**CITY OF PORTLAND, MAINE
DEVELOPMENT REVIEW APPLICATION
PLANNING DEPARTMENT PROCESSING FORM
DRC Copy**

Diamond Ave Lot #42.

RE: New Construction – Diamond Cove, Great Diamond Island

On June 15, 2001, this office, in consultation with Historic Preservation Committee Chairman, Ed Hobler, reviewed and approved your application for a Certificate of Appropriateness. Approval is for construction of a residential structure on Lot 42, Diamond Cove, Great Diamond Island. Review was based on plans dated 2/17/01, on file in this office.

LEFT SIDE ELEVATION 1/2"

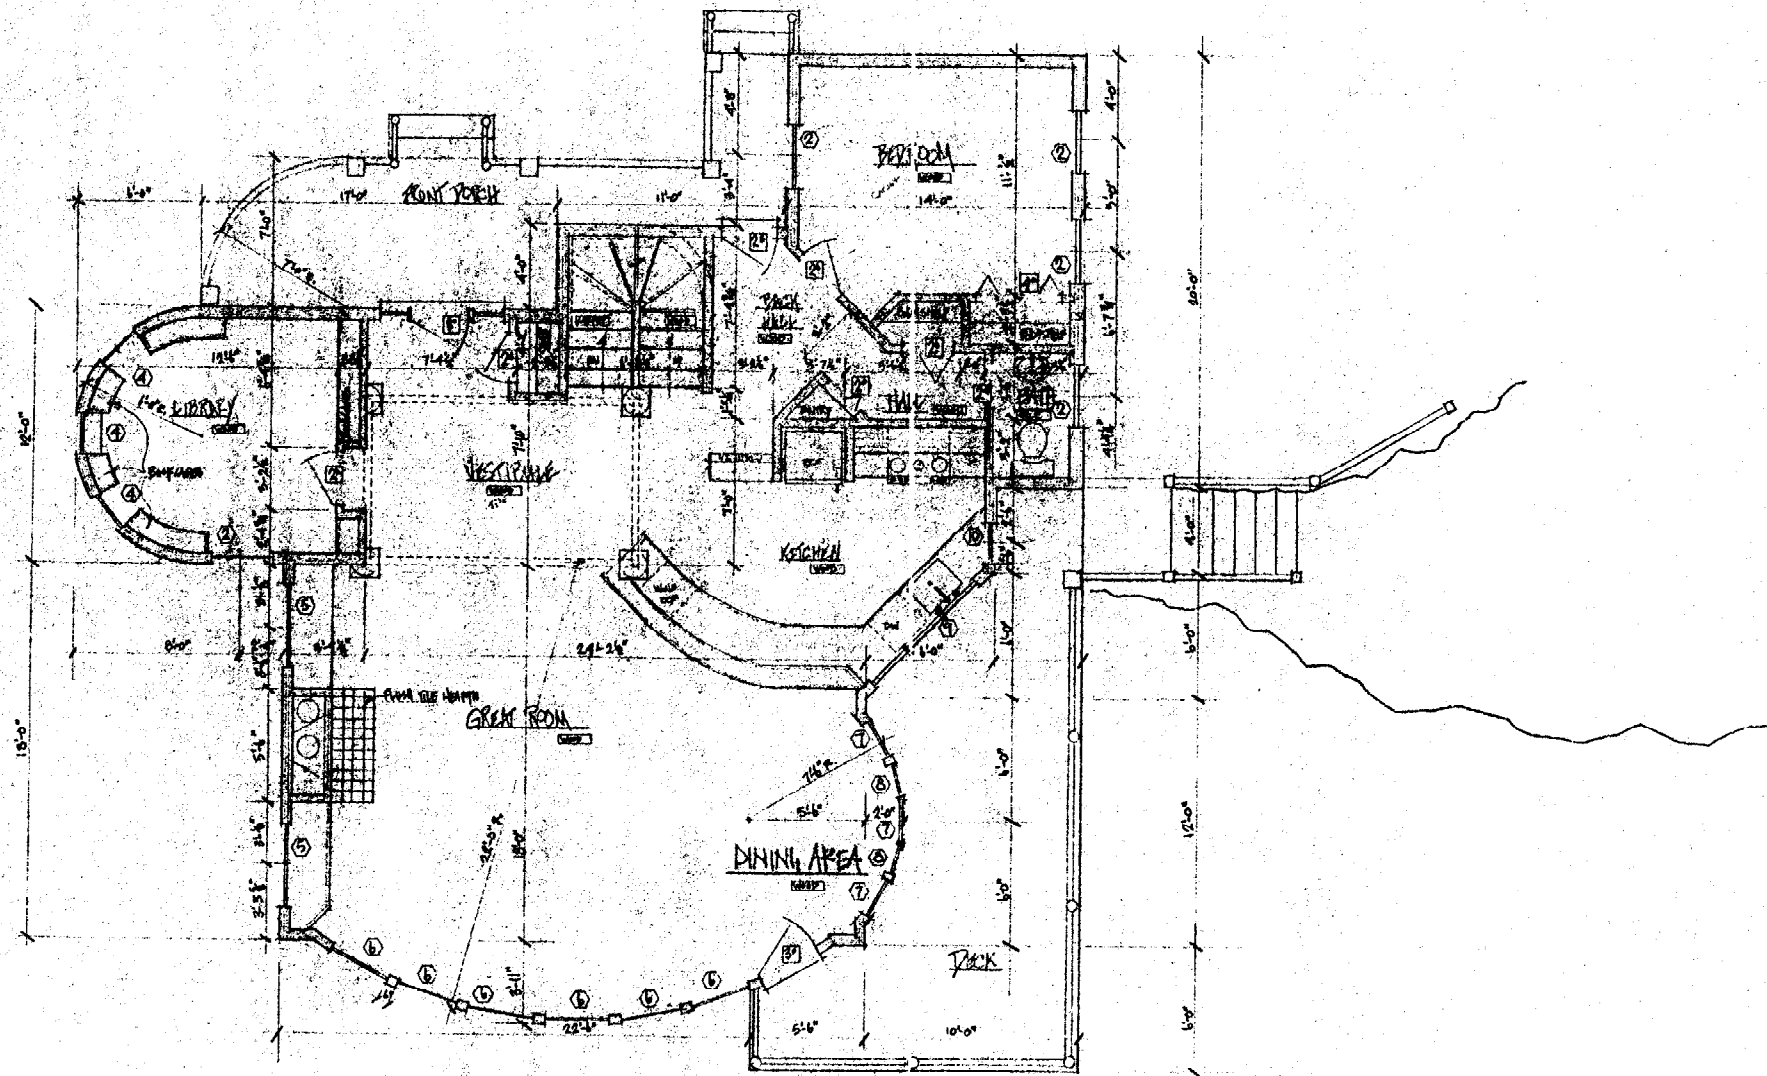
Left side elevation

1. That the Palladian-style window in the gable be simplified (see #1 under Rear Elevation, above.)

2. That the window transoms on the second floor's dining room feature divided light transoms.
3. That the paneled garage doors on the ground floor level be revised to feature "barn type" doors of vertical boards.

RIGHT SIDE ELEVATION 4"=1'-0"

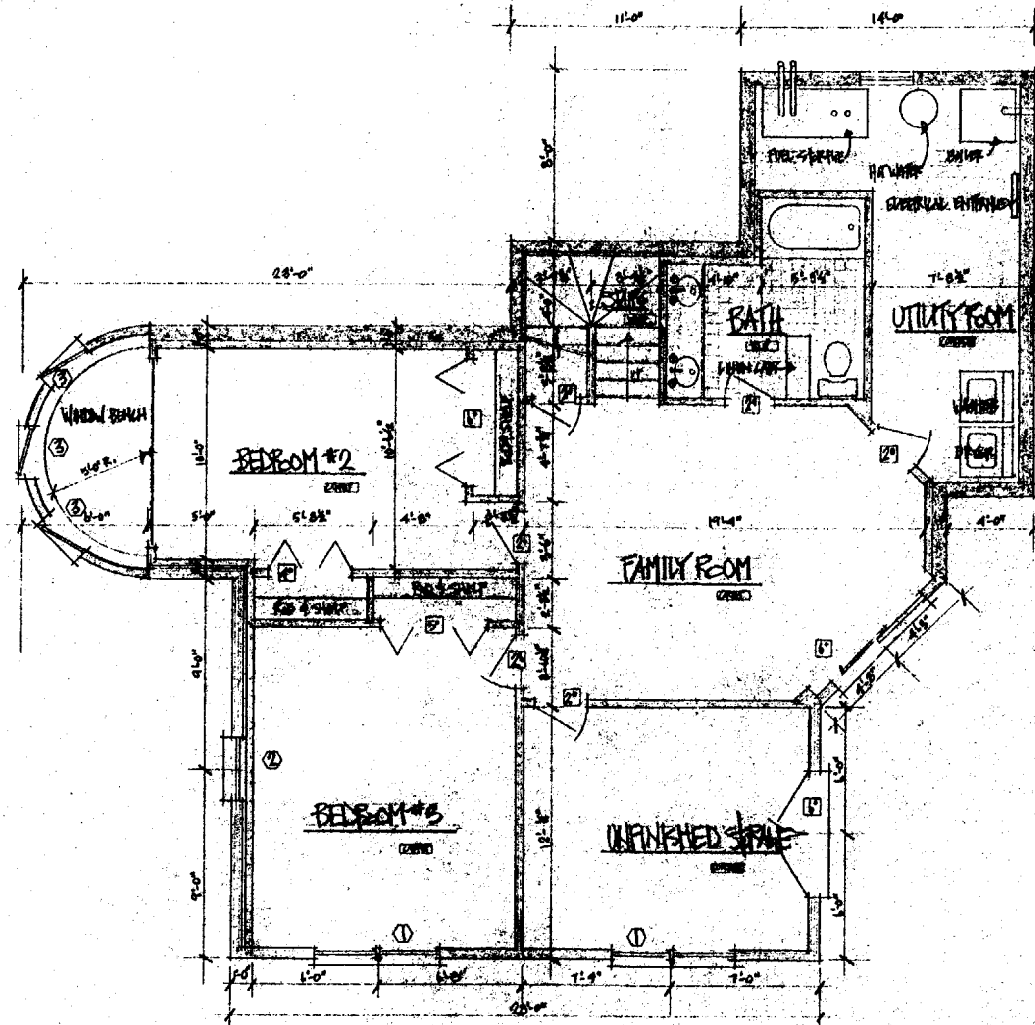
Right Side Elevation

1. That the Palladian-style window in the gable be simplified (see #1 under Rear Elevation, above.)
